Application for a non-material amendment following a grant of planning permission.

Garages Site between 15b & 17-17a Northdown Close, Ruislip

1 x two-storey, 3-bed dwelling with associated parking and amenity space, bin and cycle store, involving demolition of existing garages

APP/R5510/W/18/3215681

PROPOSED NON-MATERIAL AMENDMENT
GROUND FLOOR PLAN

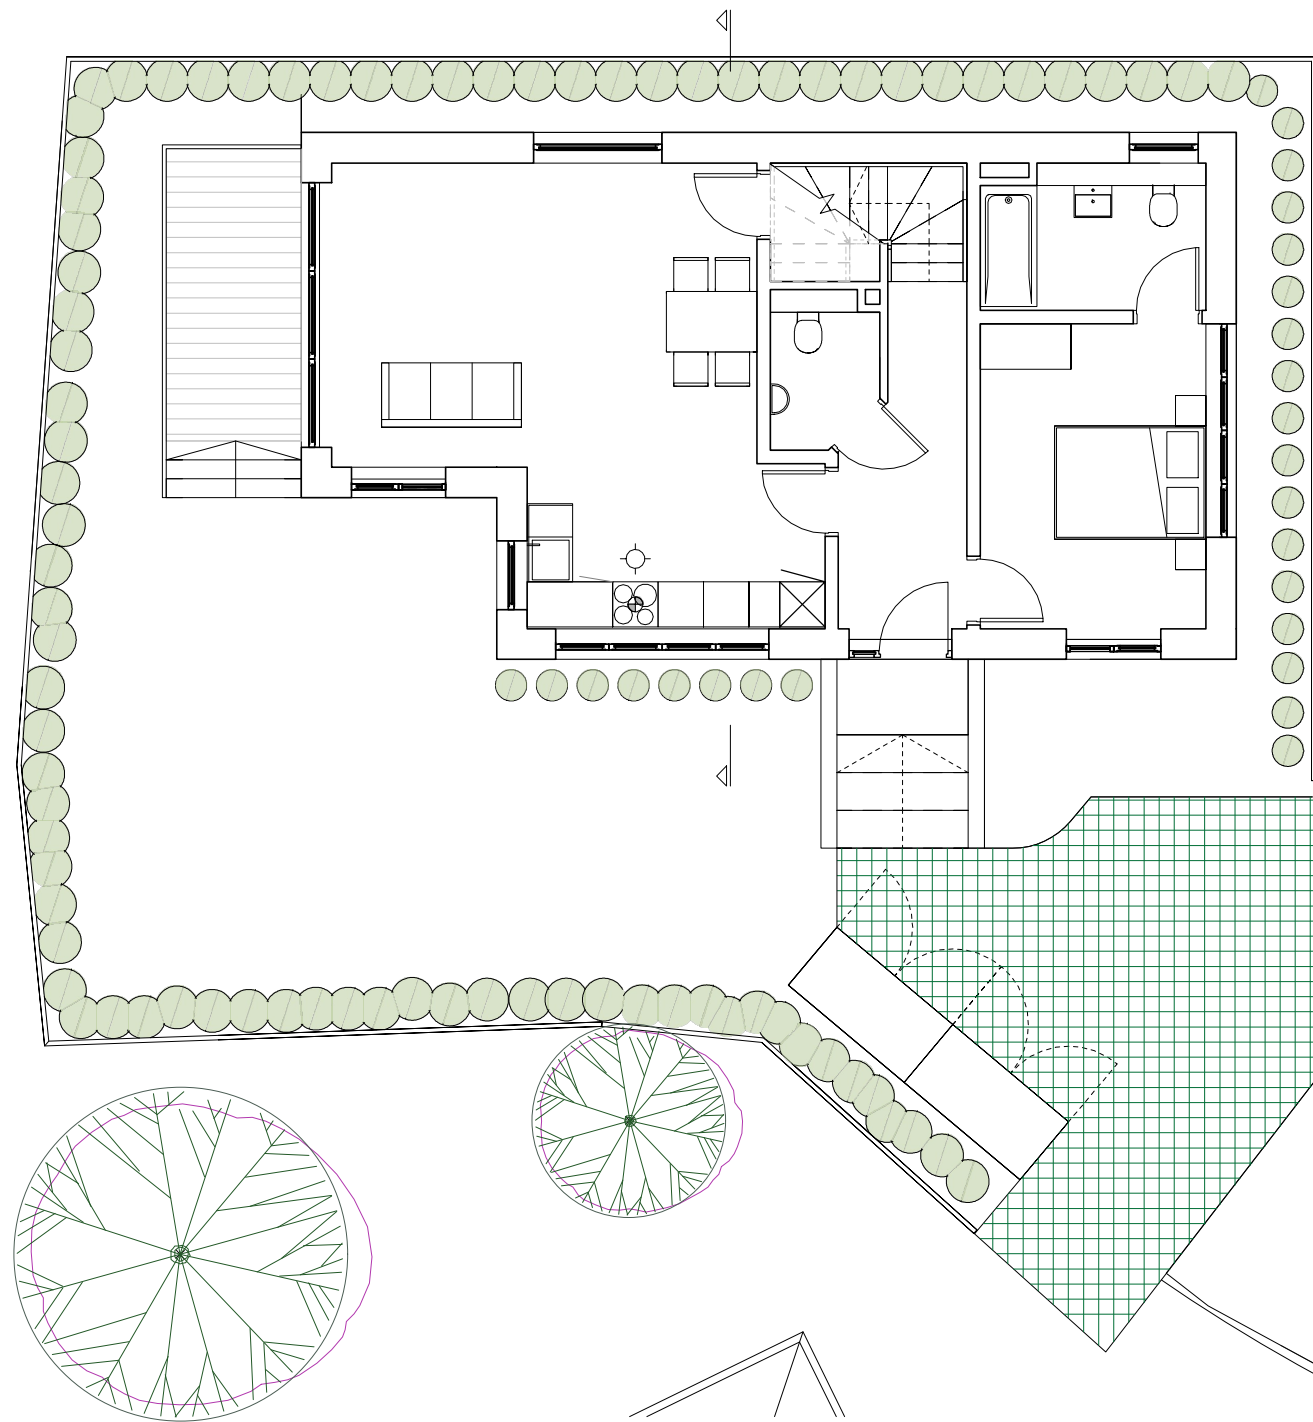
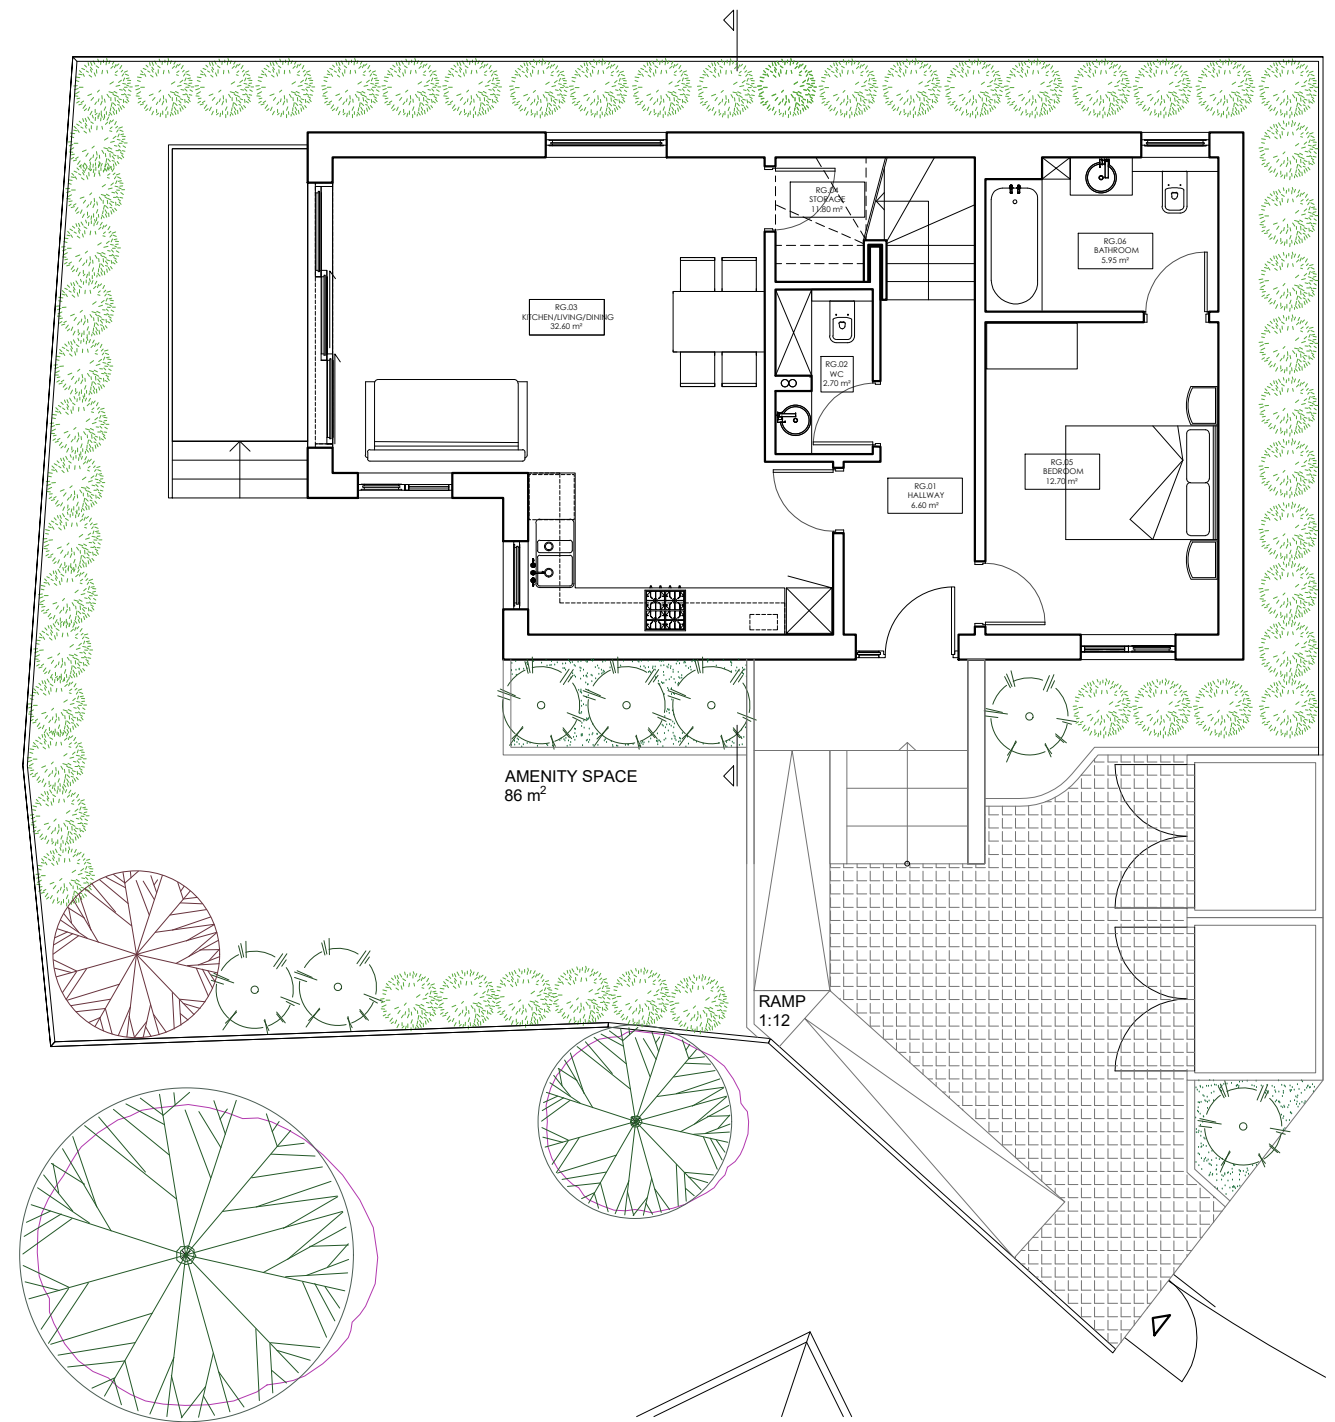
- Addition of a 1:12 ramp with 1 m width in the front of the property in the west side, where the refuse and bicycle storage were previously located, to provide an accessible route to the main entrance of the building.

- Minor changes in the width of the external stairs leading to the main entrance in order to propose the adjacent ramp. The stairs remain big enough to be practical with 1.6 m width.

- Relocation of the refuse storage to the east of the property, where it will still be accessible from the front entrance.
- Relocation of the bicycle storage to the east of the property next to the refuse storage.

- Changes in the layout of the common WC on the ground floor to improve its function.
- No major changes on the soft landscaping. The external amenity space remains the same and there are two types of trees (Cupressus, Prunus Cerasifera) and two types of bushes (Aucuba Japonica, Prunus Laurocerasus) introduced.

PROPOSED NON-MATERIAL AMENDMENT
ROOF PLAN

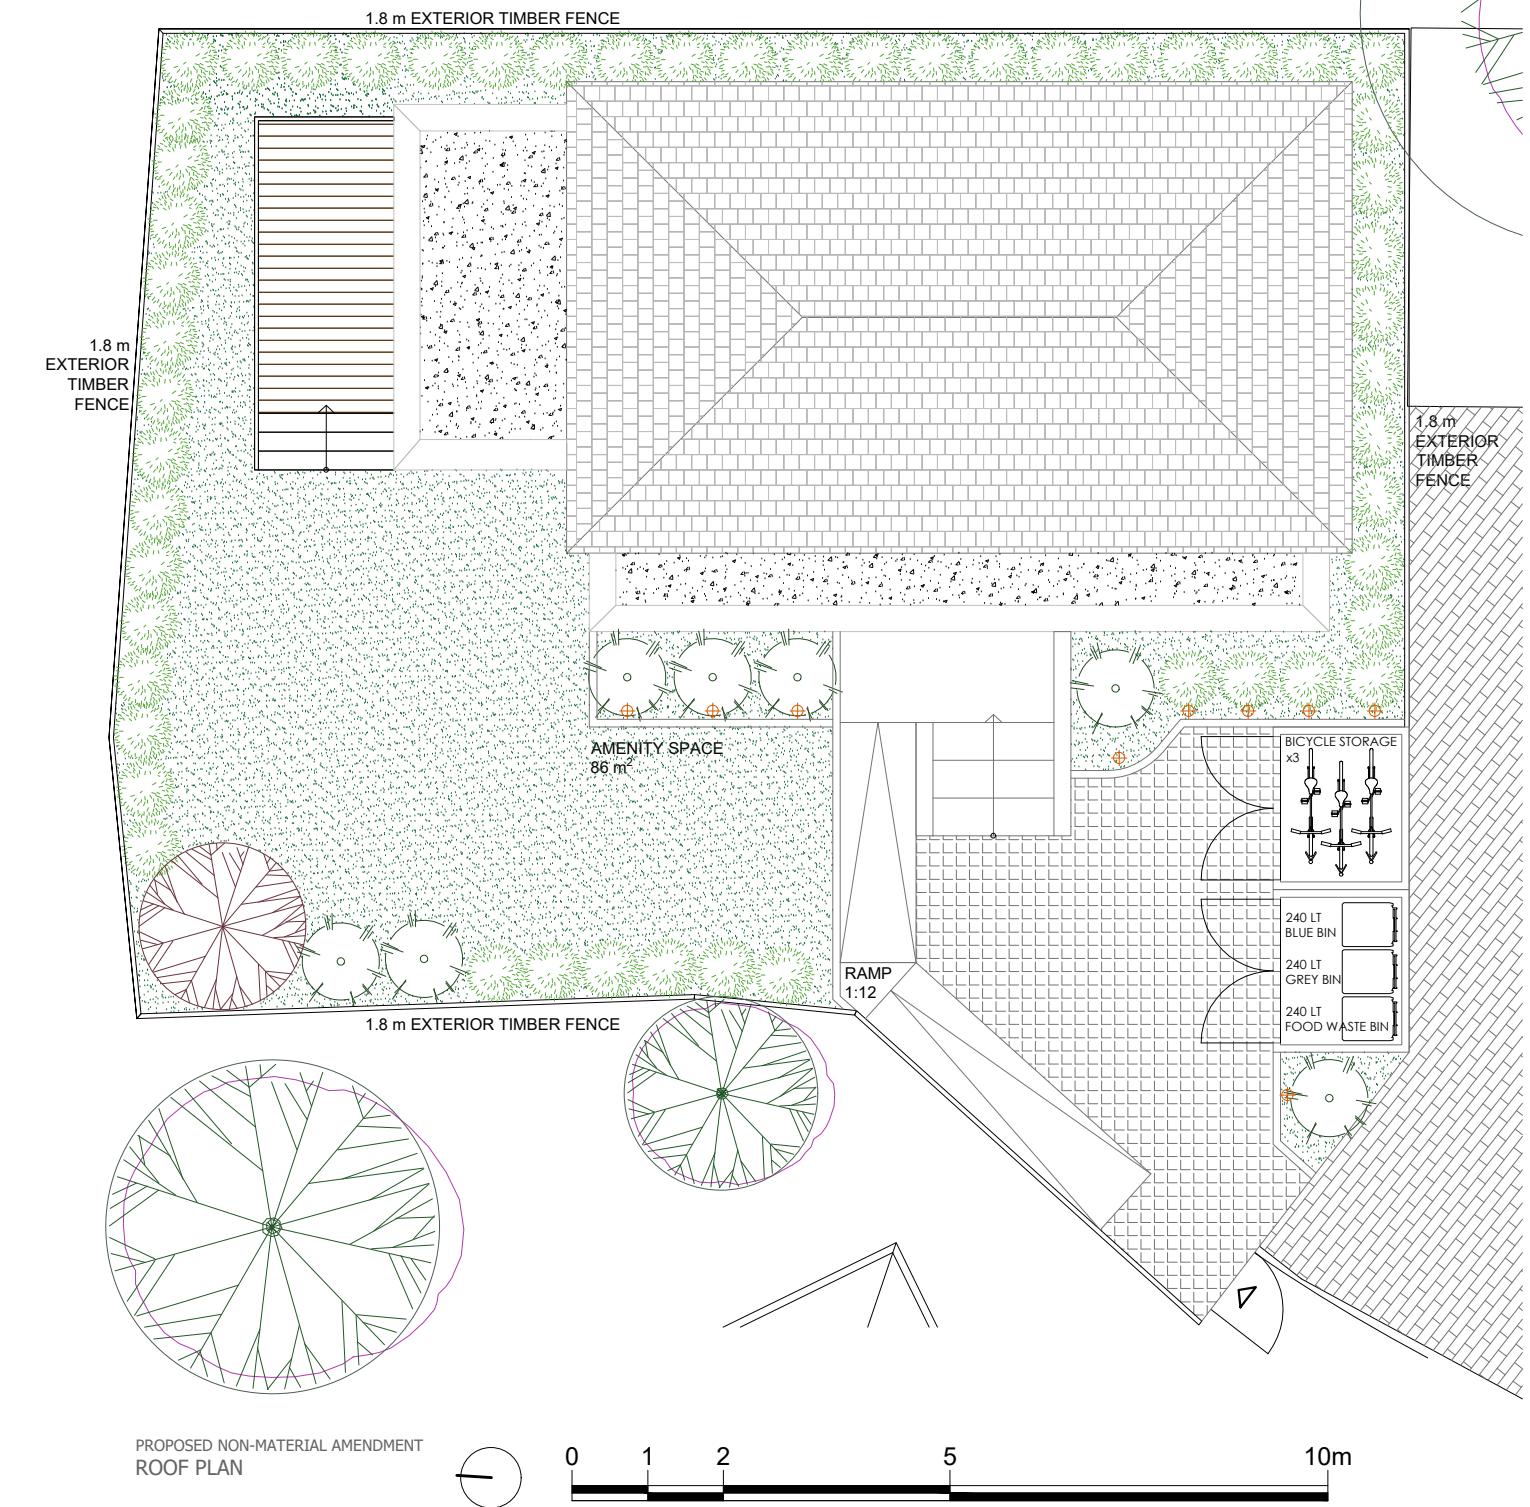
- Removal of the 4 rooflights as there is no proposed loft and there is no need for openings on the roof.
- Removal of the 4 windows on the front facade on the ground floor, where the kitchen is located. These windows are too tall and not practical for the use of the kitchen. The kitchen/living/dining area will receive enough light from the rest of the windows.

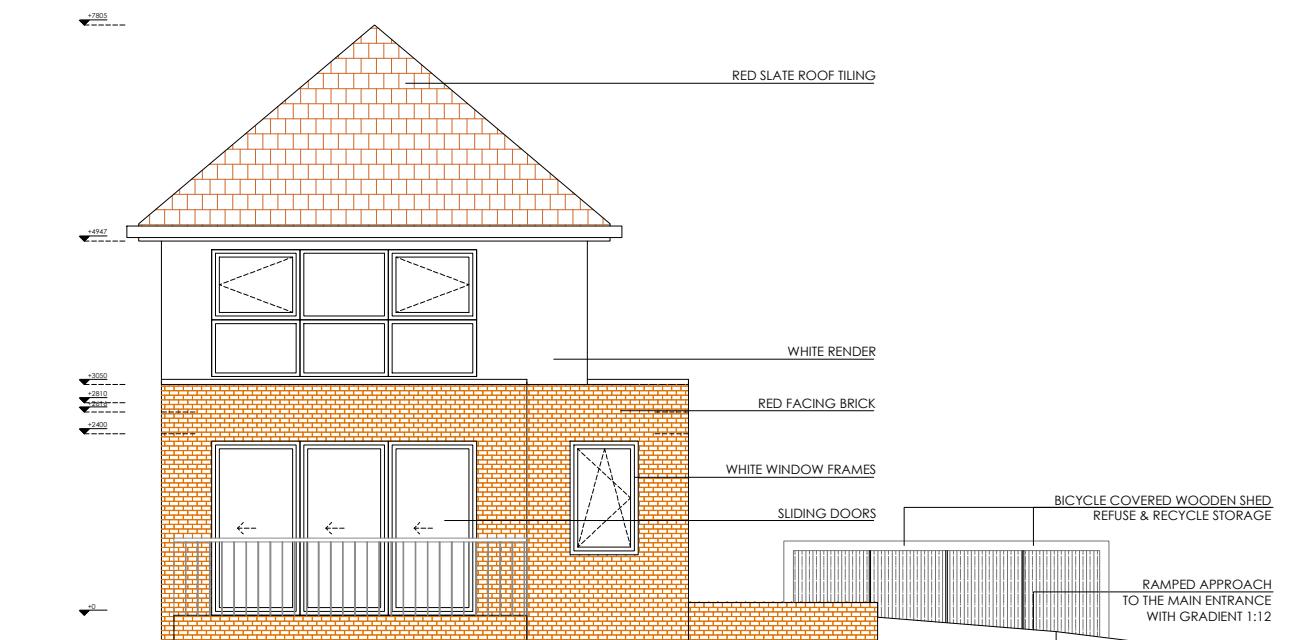
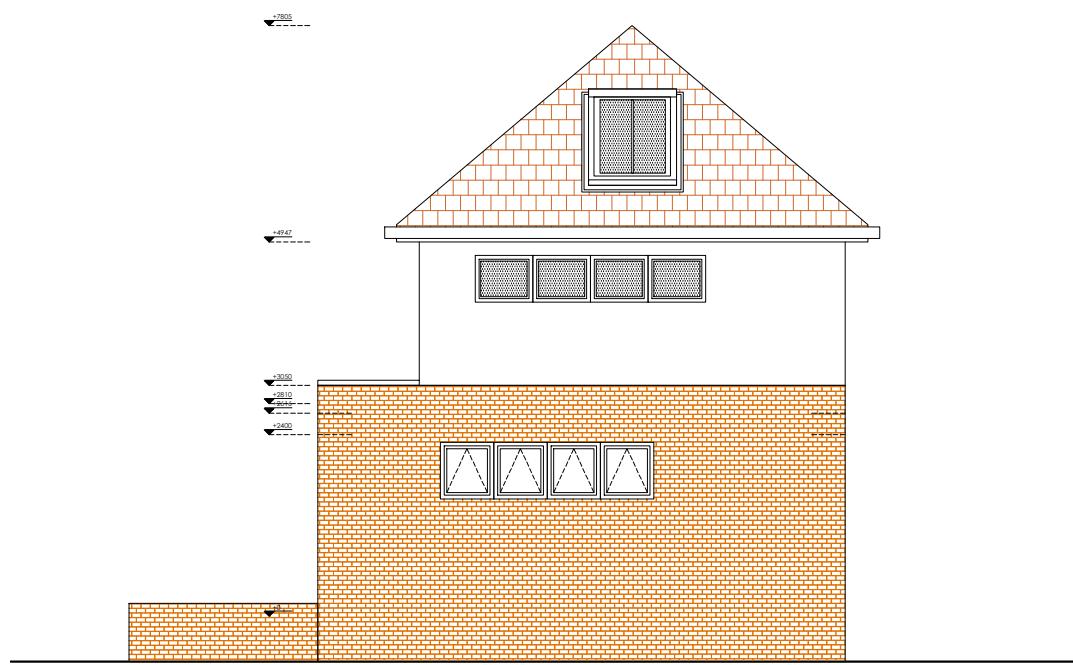
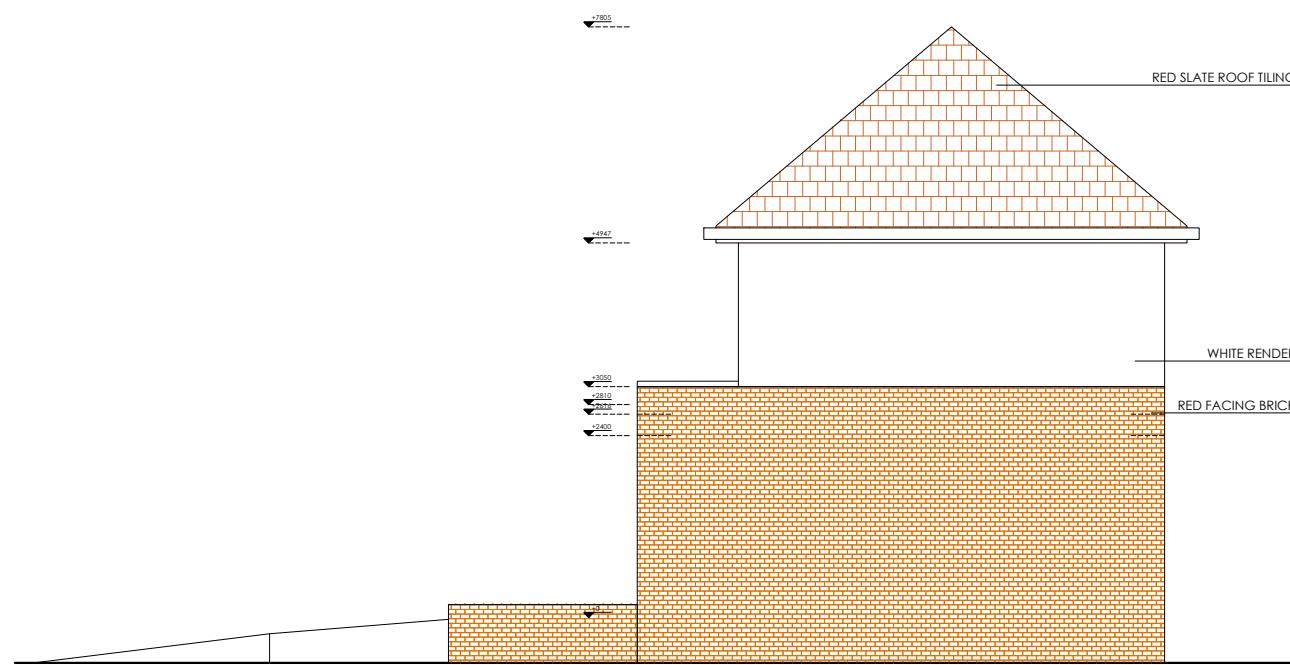
- Removal of the 4 windows on the ground floor and 4 windows on the first floor on the south side elevation. These windows are too tall to be practical. The rooms that they facilitate will receive enough light from the windows on the other sides.
